Our Ref: DOC17/608360

Request for response to revised plans – O’Connell Street Public School Redevelopment (SSD 7372 MOD 2)

Figure 27: Building B Roof Plan, showing the revised layout of the plant platform.

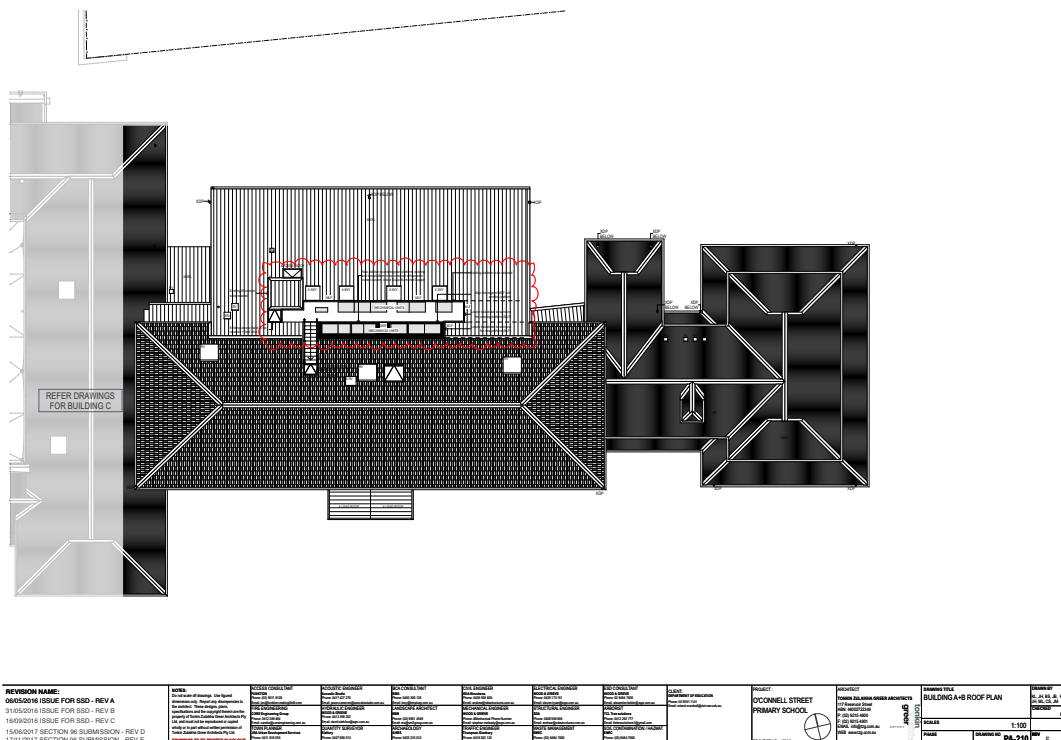
The proponents preferred option (option 5) proposes to reconfigure the existing mechanical plant by incorporating new condenser units to the south between the existing units and the rise of the building's roof. It is noted that this option would utilise the existing reticulation lines and infrastructure while increasing the capacity of the current air conditioning system. This option would result in a slight increase in the bulk of the approved plant and a significant decrease in the bulk of the illegally constructed plant that is currently situated on the roof. The physical impact of the expansion southward as described would have a minor and negligible impact to significant fabric.

On balance, the Heritage Division considers option 5 to be the most practicable due to the minor amount of modifications to existing services required to achieve the desired increase in capacity. Option 5 would have a slightly increased visual impact to the site over the approved plant, however this increase in bulk is considered to be minor and as the plant is located on the northern side of the building away from the most significant views of the site, the visual impact is considered to be acceptable.
